Subject: Re: Sefter Road, Bognor Regis - discharge of condition for drainage

My comments are as follows:

Flow Control Chamber SWMH1.19

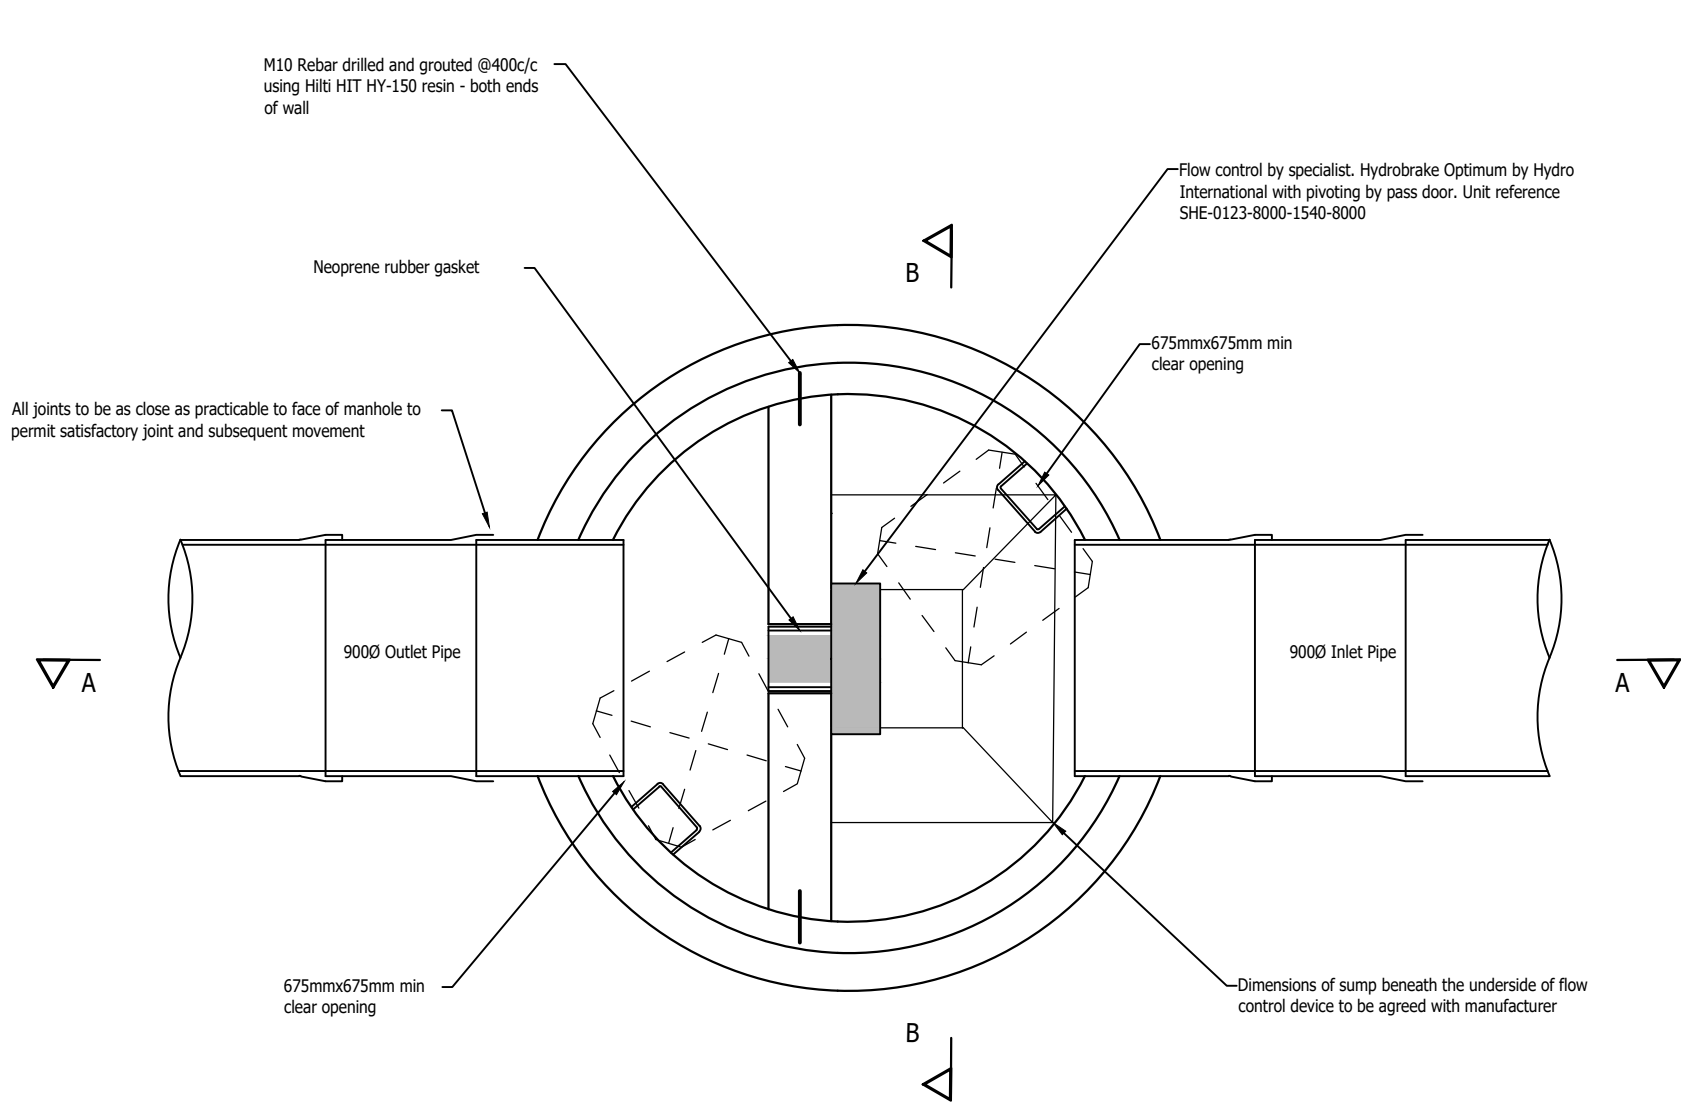
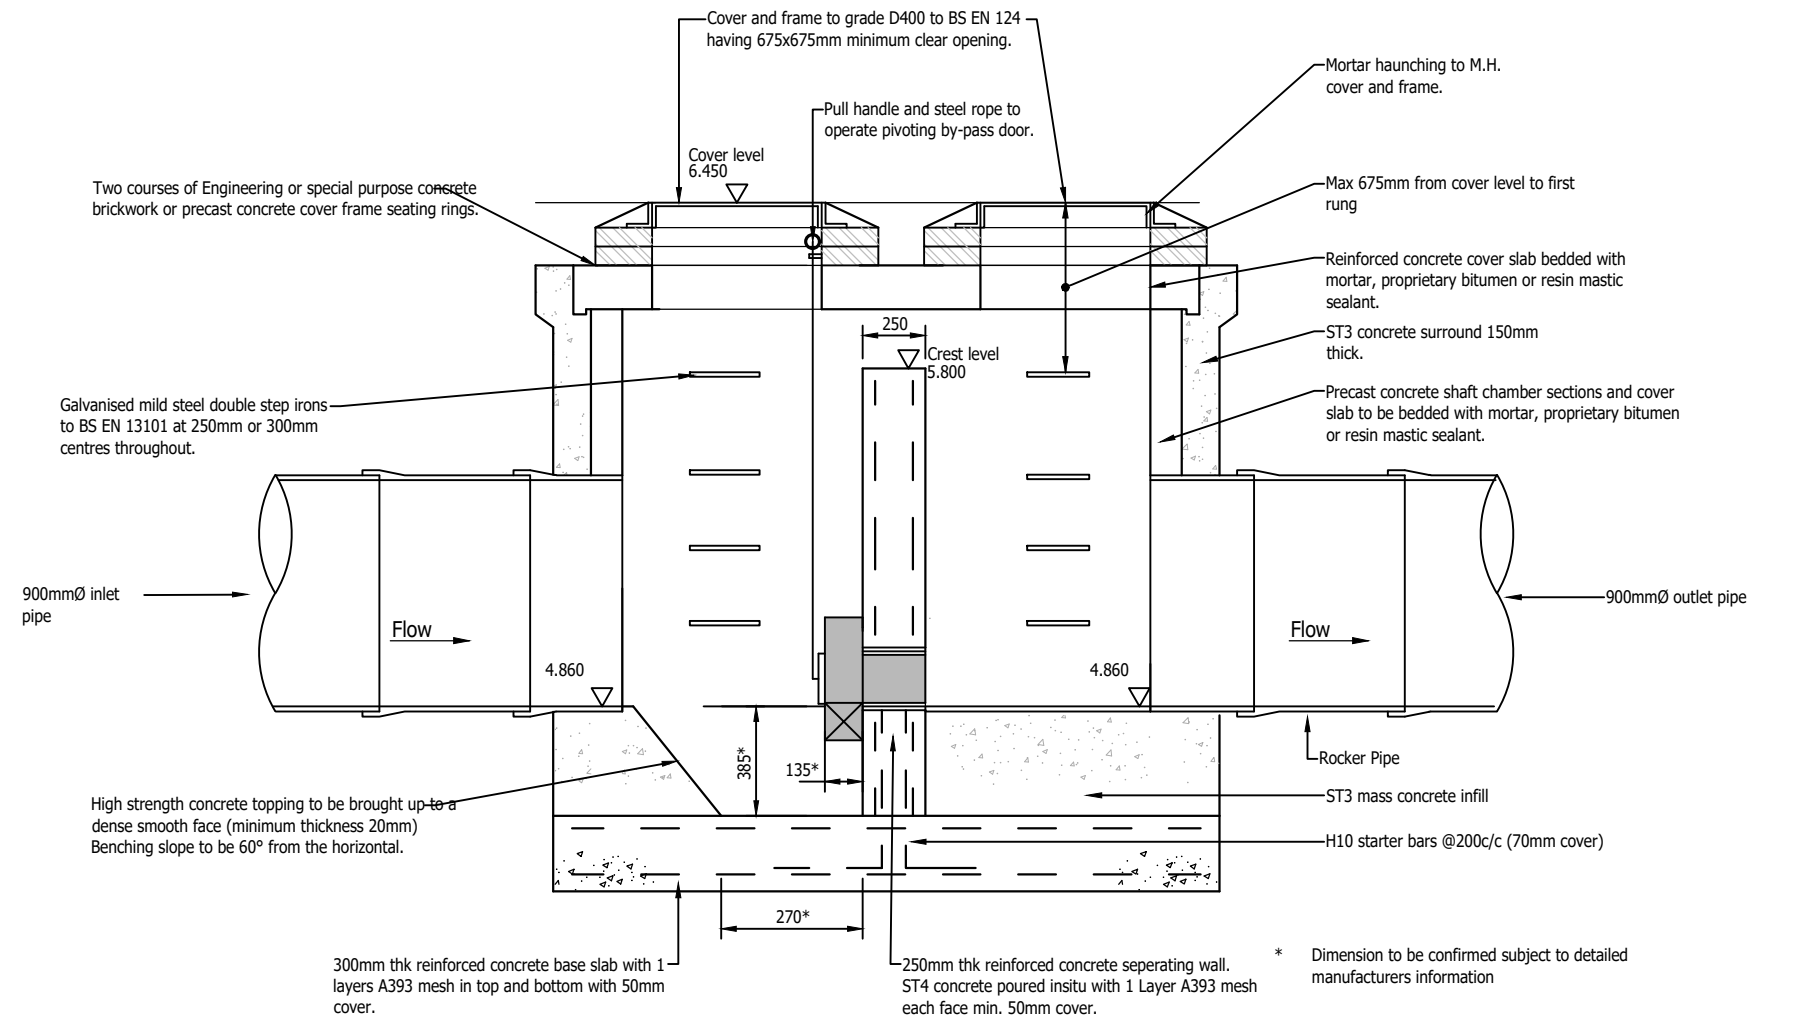
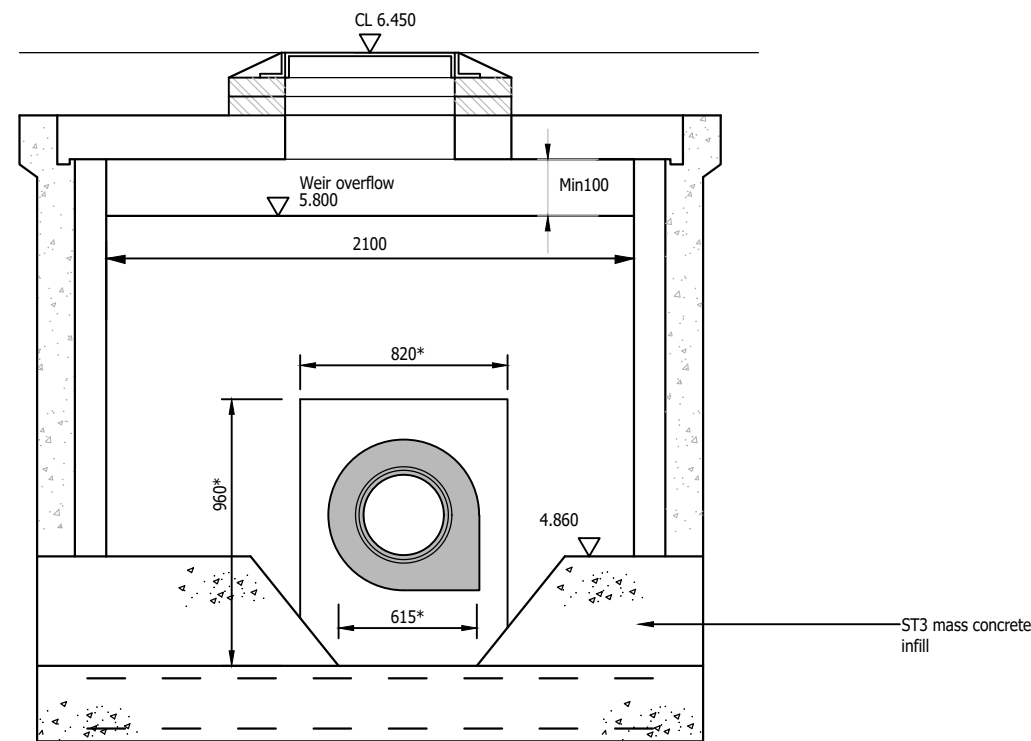
5. Please detail what material lifting rings are to be pointed with.
6. Please detail flow control chamber weir and overflow levels.
7. SWMH17.9 hydrobrake unit reference is inconsistent between construction detail and calculations.

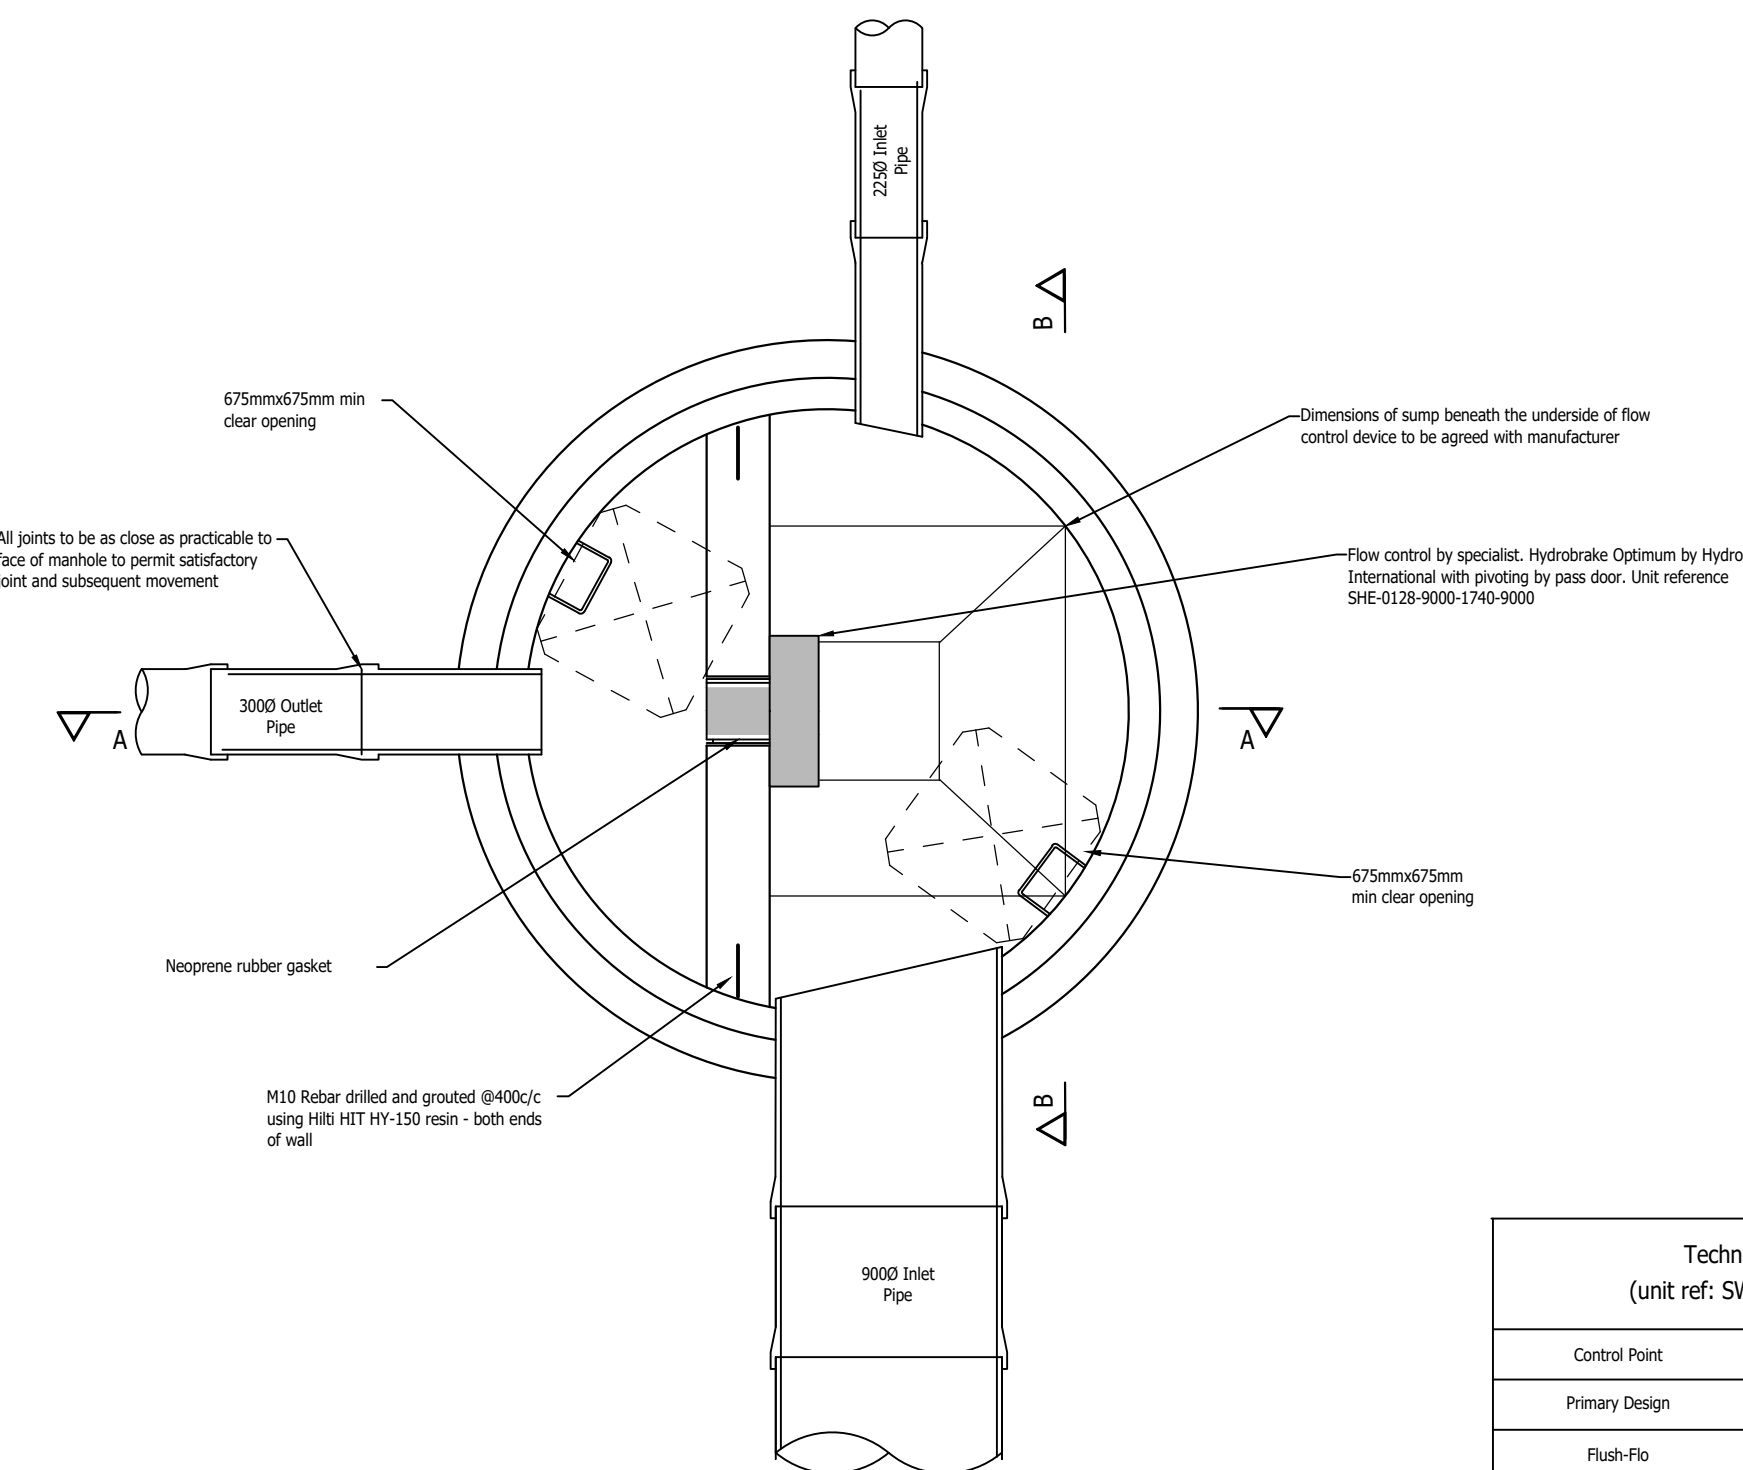
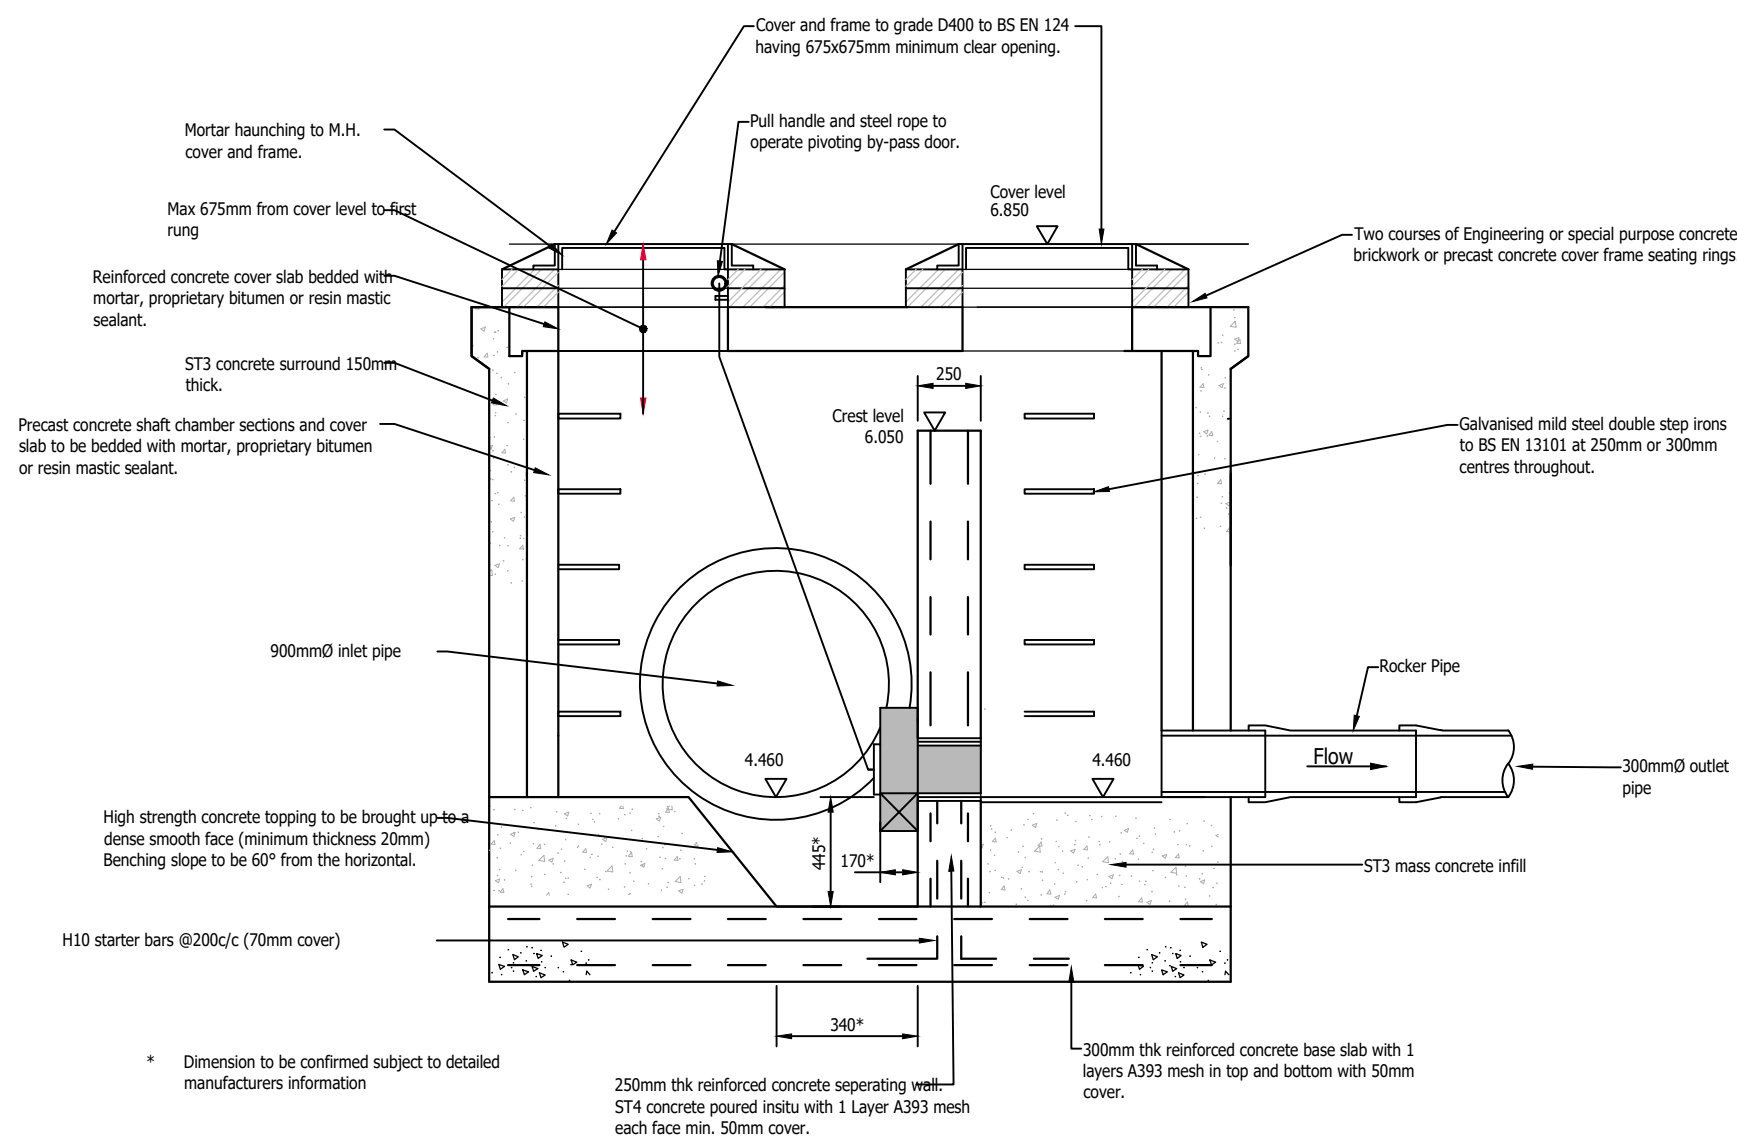
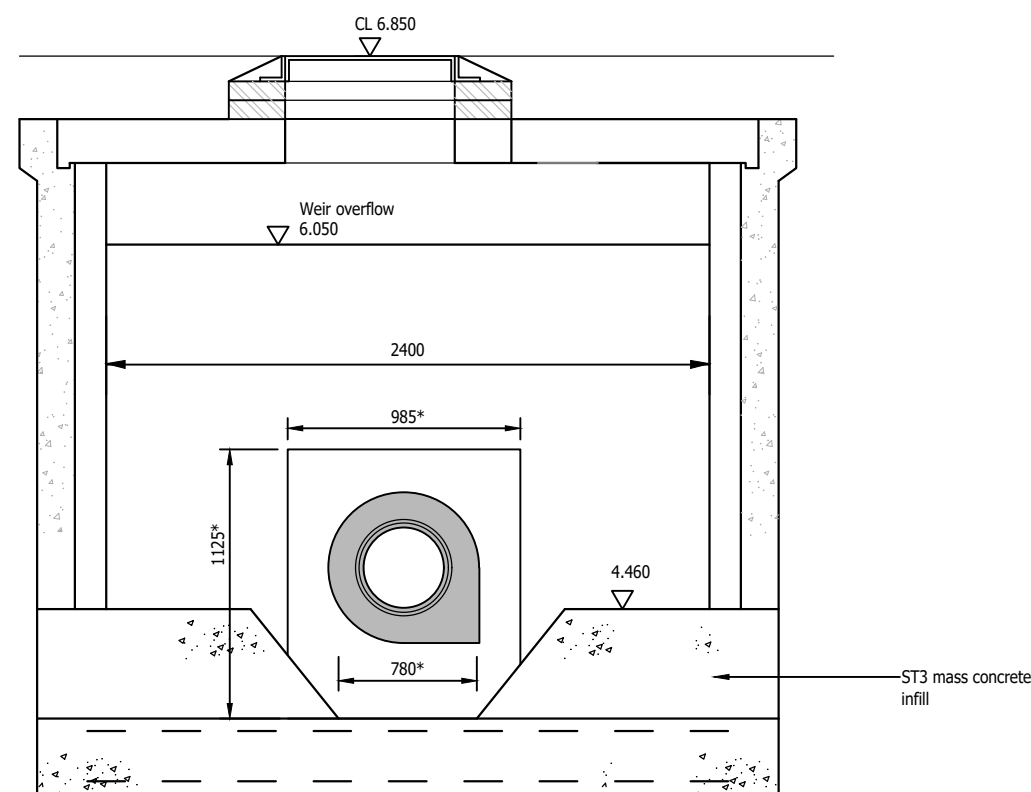
8. SWMH1.19 has a predicted water level of 5.974mAOD. This has a labelled cover level of 6.3mAOD, given slab thickness, cover frame thickness and requirement for at least two courses of engineering bricks it is evident that the crest level of the weir will not be able to be located above this water level. Please review cover level or hydrobrake specification.
